KITTITAS COUNTY

DEPARTMENT OF PUBLIC WORKS

MEMORANDUM

TO: All Staff
FROM: Public Works Plan Review Team
DATE: February 3, 2025
SUBJECT: SP-25-00001 Graf

GRAF SHORT PLAT

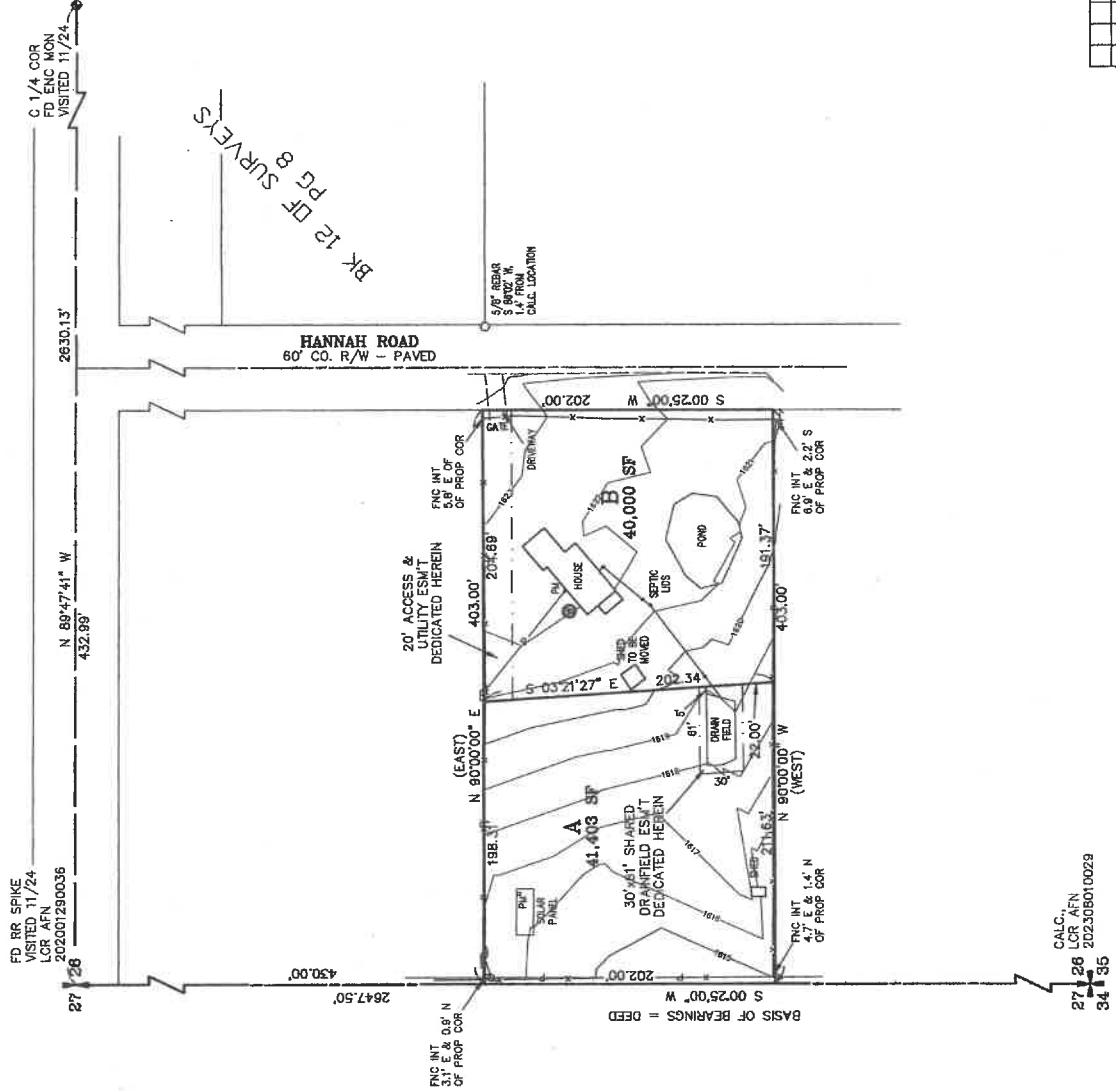
SURVEY	<ol style="list-style-type: none">1. As the Prelim Short Plat shows elevations, it will need to meet the requirements of WAC 332-130-145. <p>The following reflect changes that will need to be shown on the final Short Plat:</p> <ol style="list-style-type: none">2. The Basis of Bearing should refer to a document of record for the Deed. (EX: Basis of Bearing=Deed (AFN:12345))3. Label Bender Road (label only, width and surfacing not required)4. Set and show property corners.
TRANSPORTATION CONCURRENCY	No transportation concurrency requirement for this project. (KAH)
FLOOD	Parcel #841133 is not mapped within the FEMA identified special flood hazard area (100-year floodplain). A floodplain development permit is not required for the proposed project. (SC)
